From: Fiona Fitzgerald <Fiona.Fitzgerald@arun.gov.uk>
Sent: 04 February 2021 10:53
To: Planning.Responses <Planning.Responses@arun.gov.uk>
Cc: Michael Eastham <Michael.Eastham@arun.gov.uk>
Subject: Y/9/21/DOC

Please could the applicant confirm that 100% of the houses with a driveway or a garage have an EV charging point as this is not clear from the plan?

Title:
CAR CHARGING POINTS PLAN

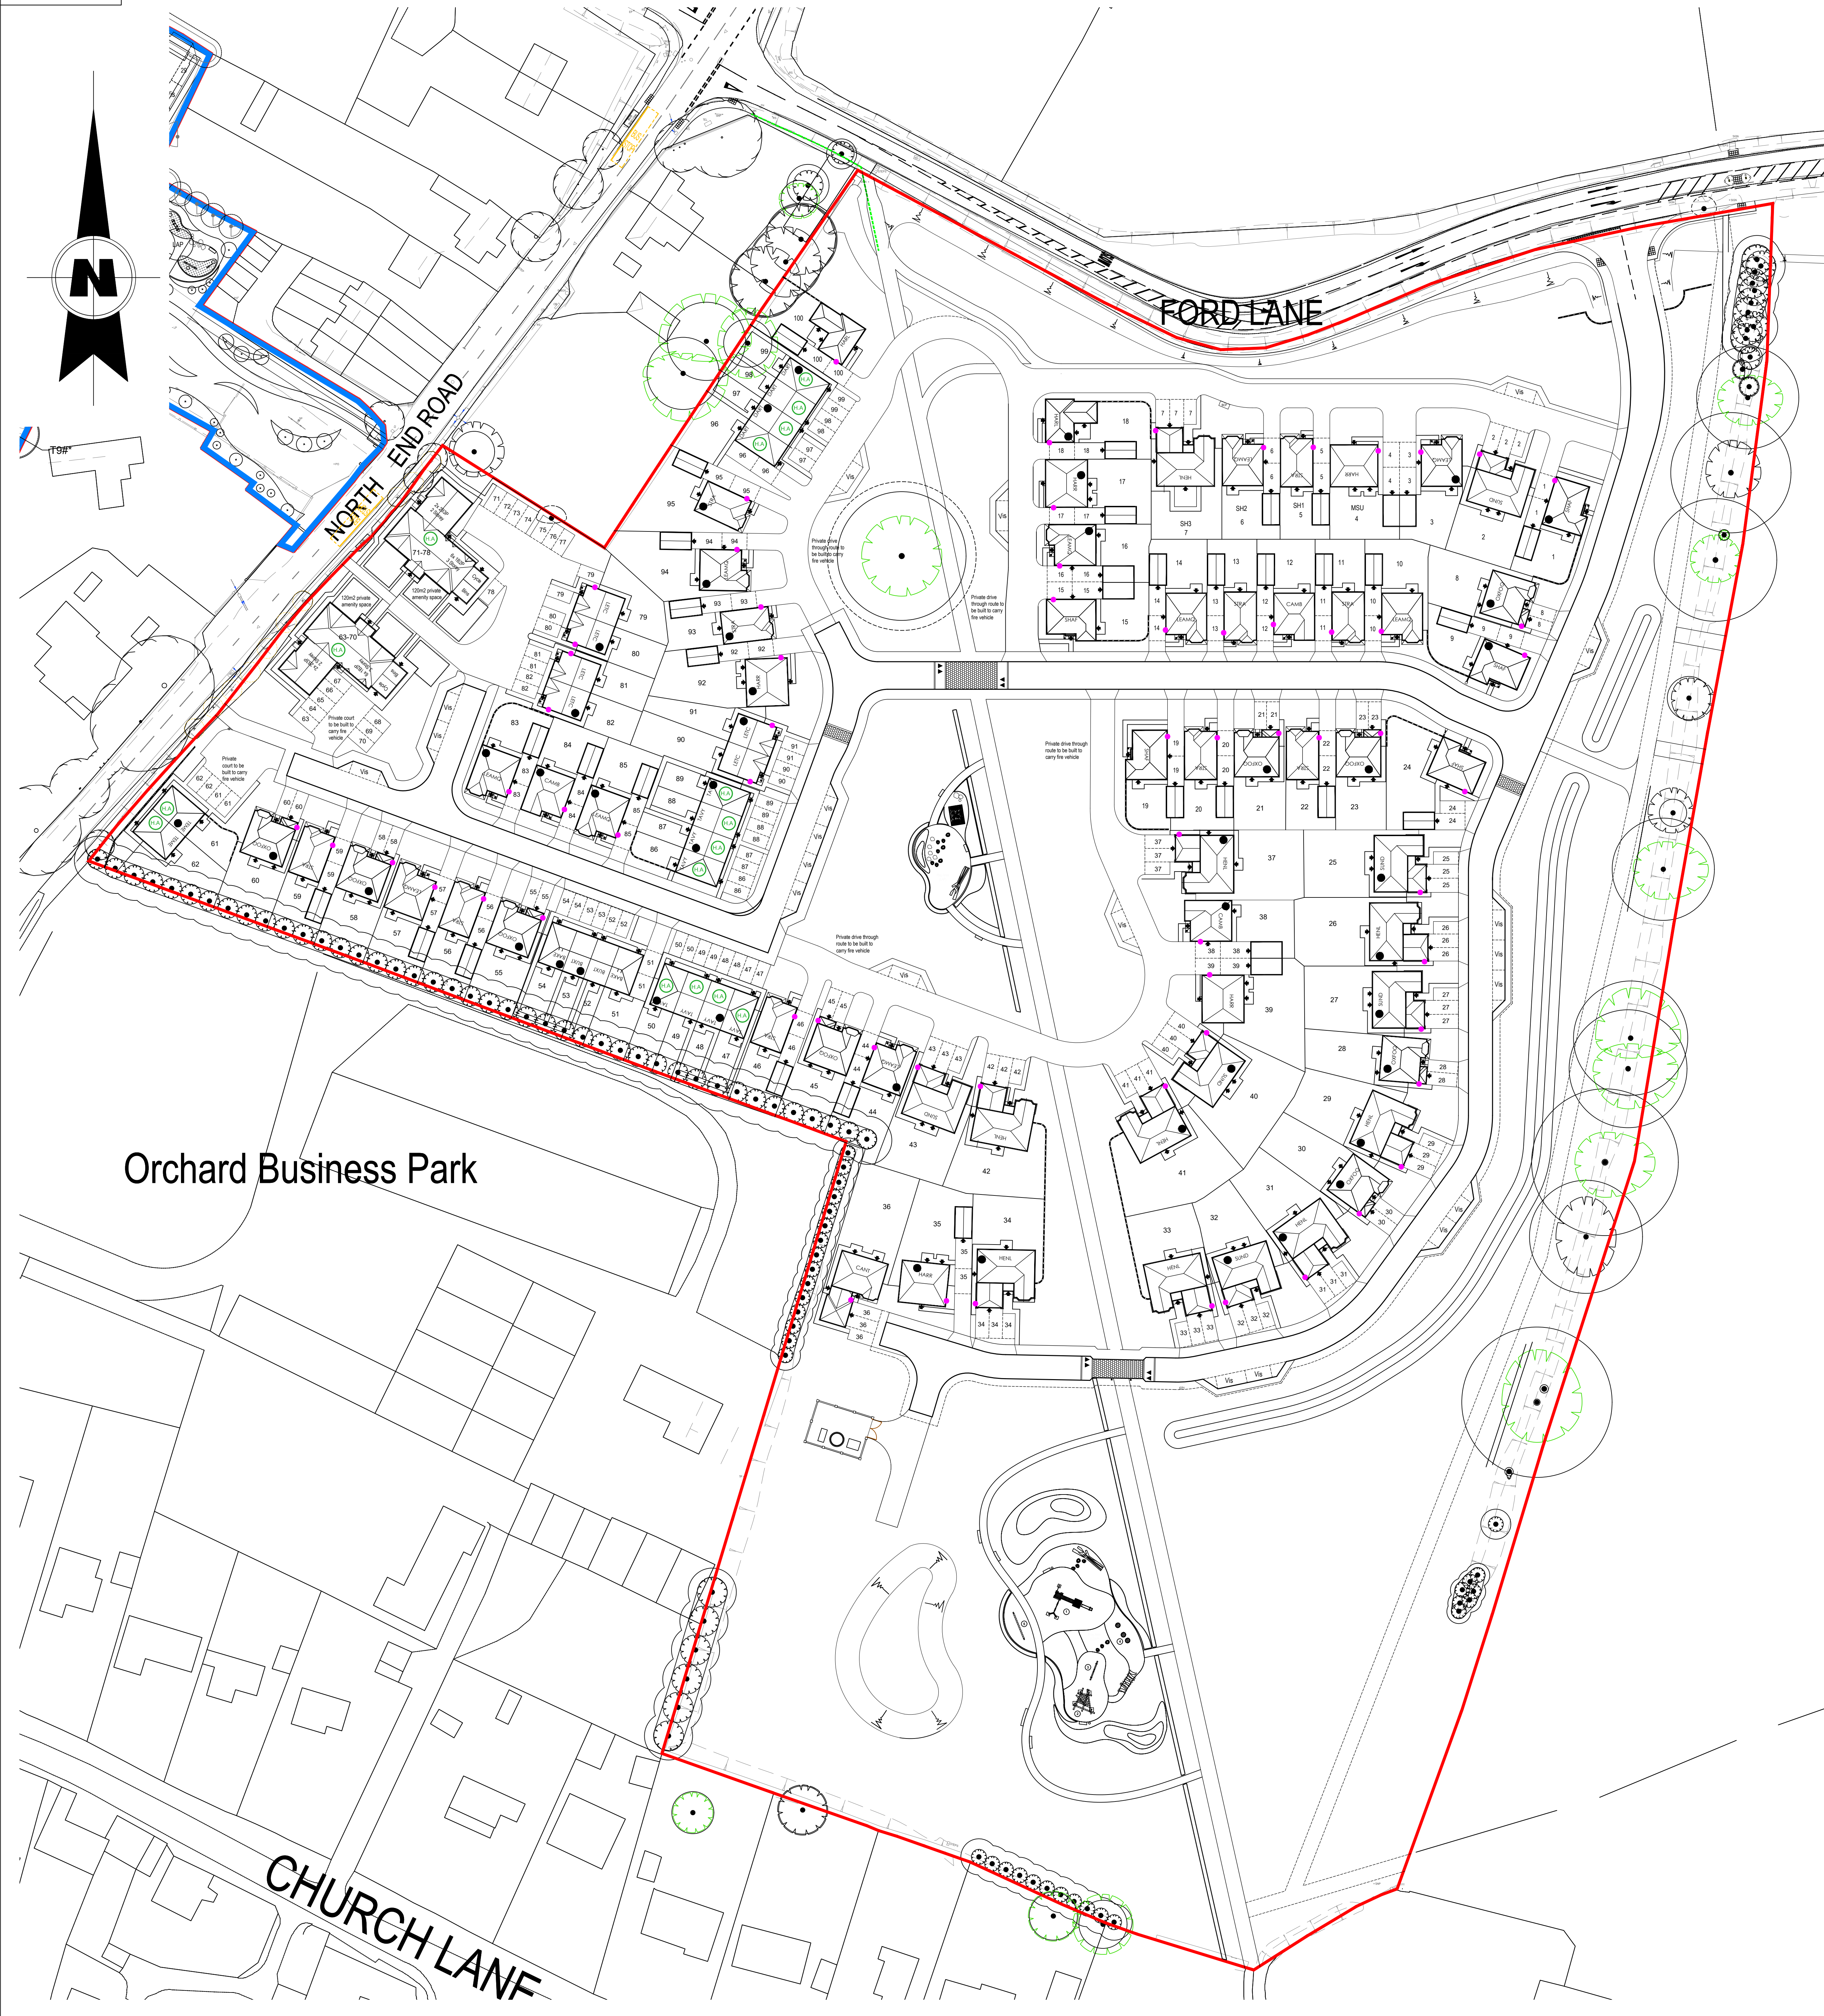
It would appear that dwellings falling under 'all other developments' such as flats and housing association properties do not have access to EV charging points. There is a requirement under the Arun Parking Standards for a certain percentage of these to have access to EV charging points.

Therefore, at the present time, Environmental Health is not satisfied that this condition can be discharged.
